Non-Material Amendment to Planning Permission Ref. BE/135/18/PL – Salt Box, Land off Rowan Way, Bersted, PO22 9NW

On behalf of our client, ALDI Stores Ltd. (ALDI), please find enclosed an application made pursuant to Section 96A of the Town and Country Planning Act 1990 (as amended) for a Non-Material Amendment (NMA) to planning permission ref. BE/135/18/PL.

EAST ELEVATION

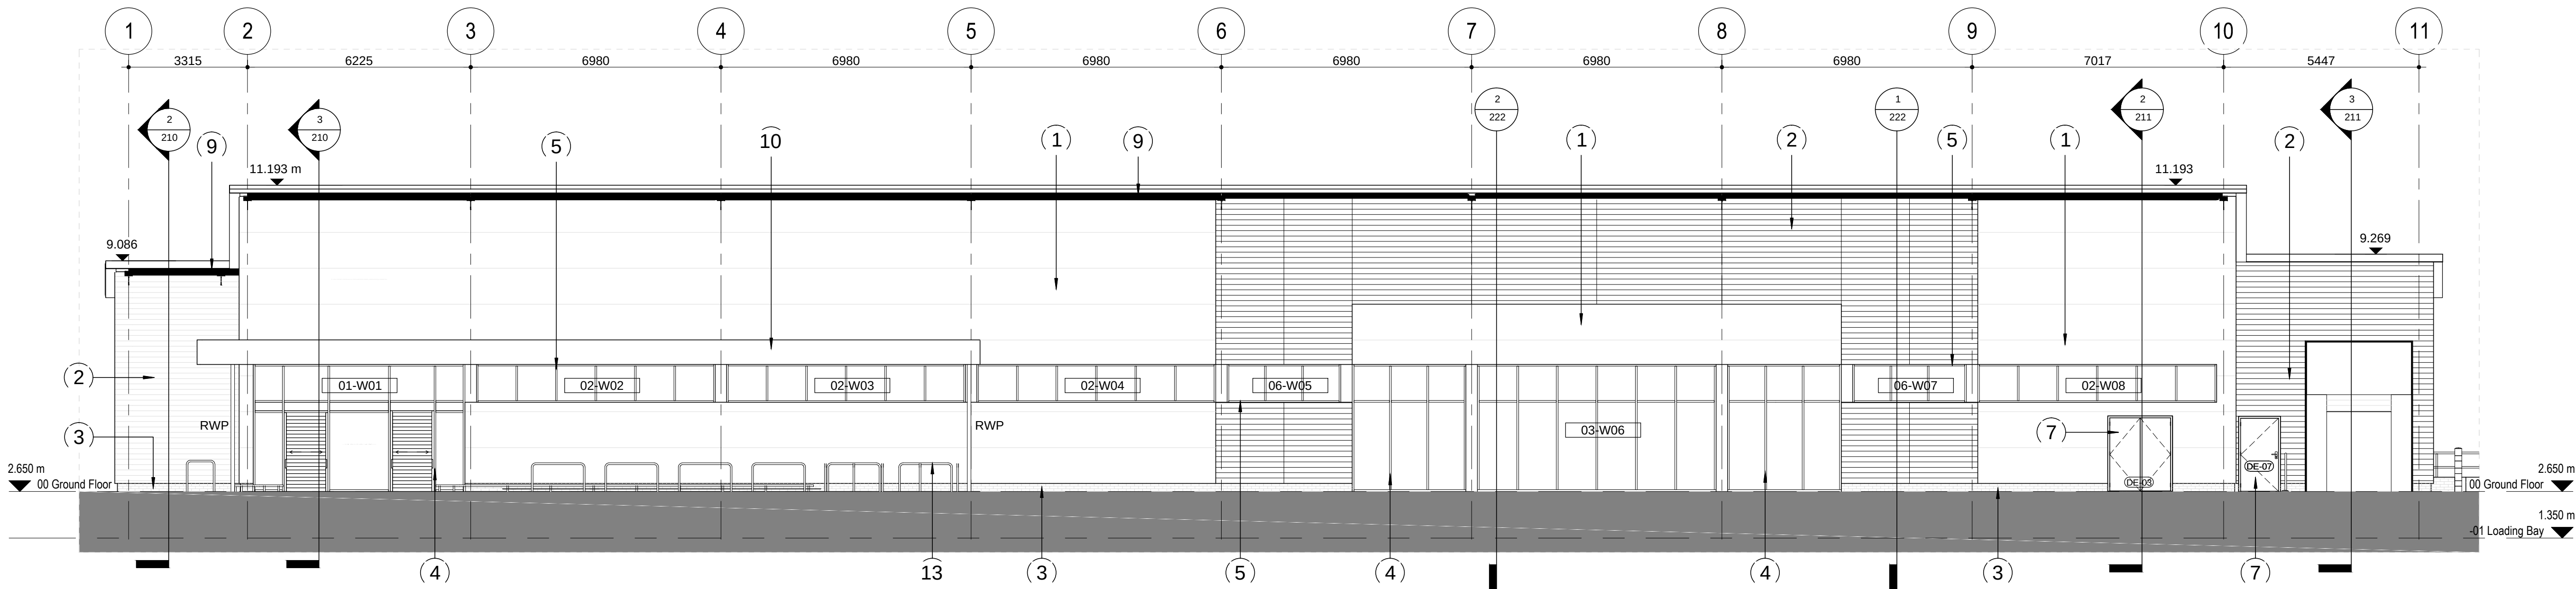
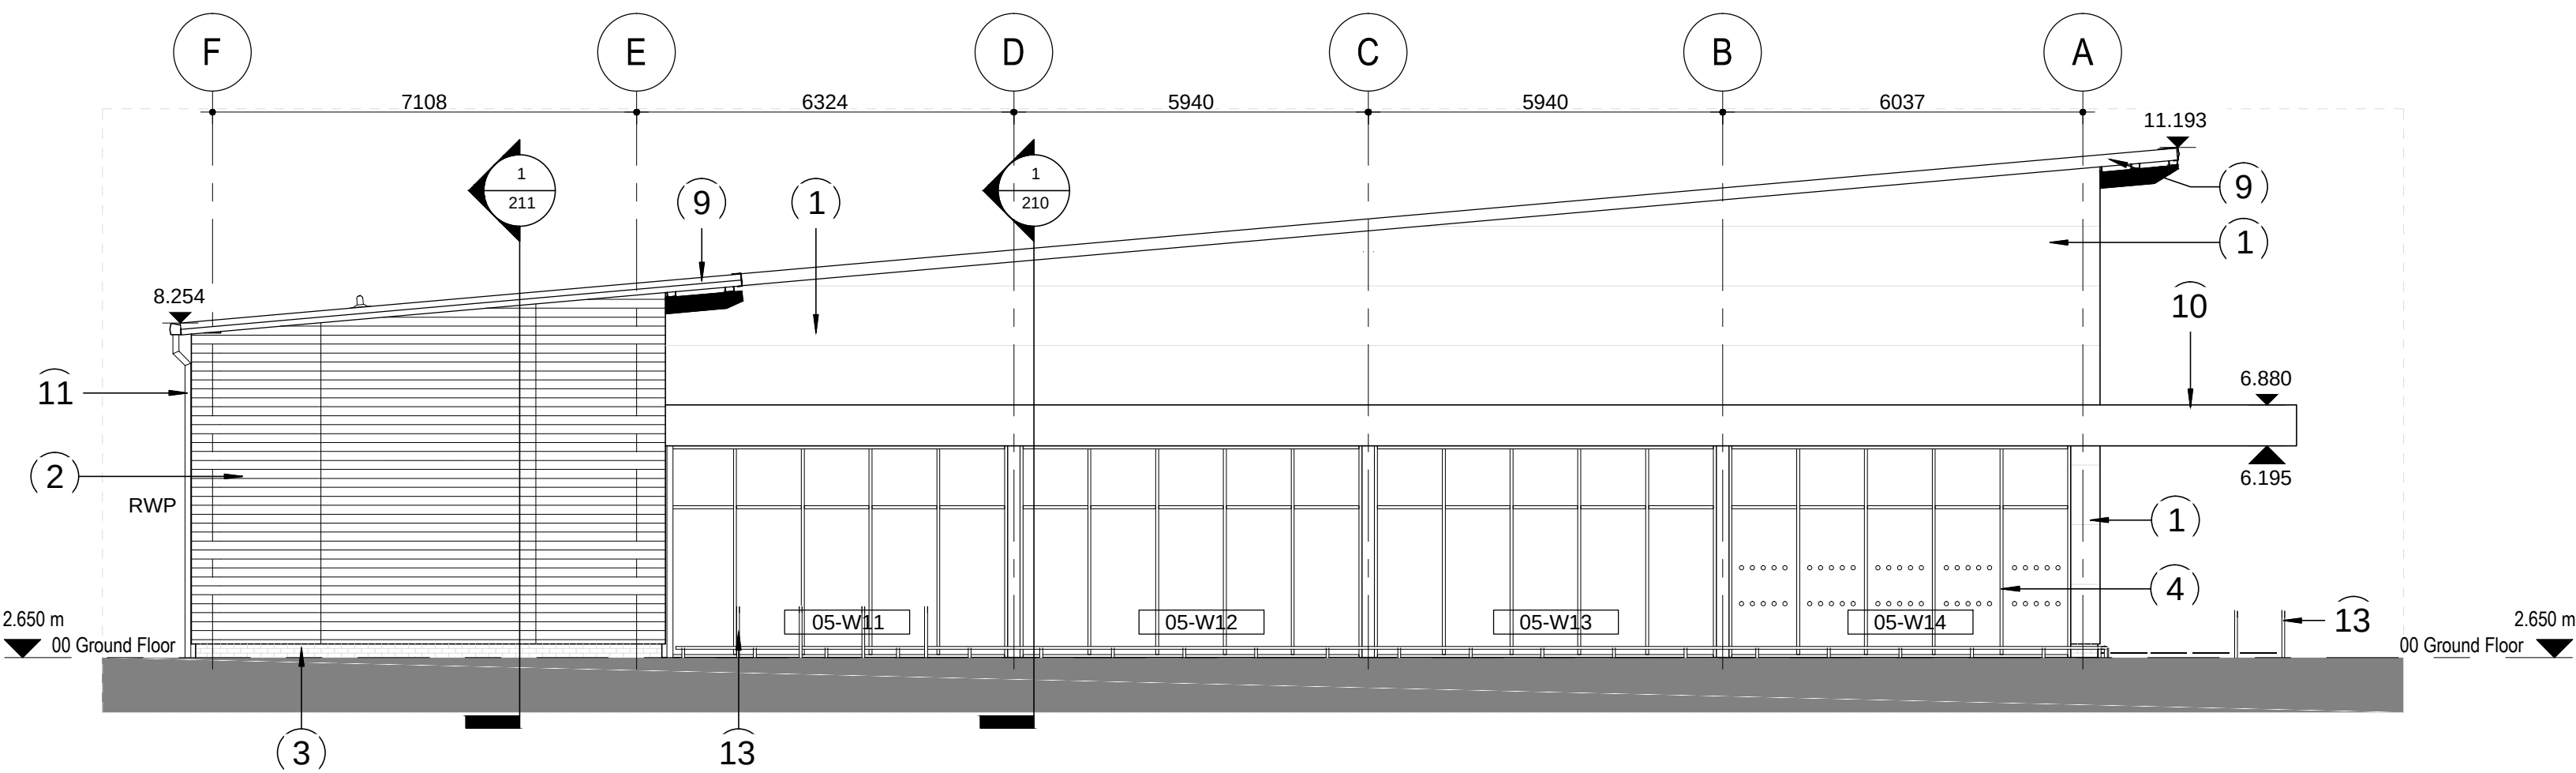
The revisions represent a minor external design change to the store's elevations, changing the currently approved cladding to a 'Duraclad' Composite Timber Cladding.
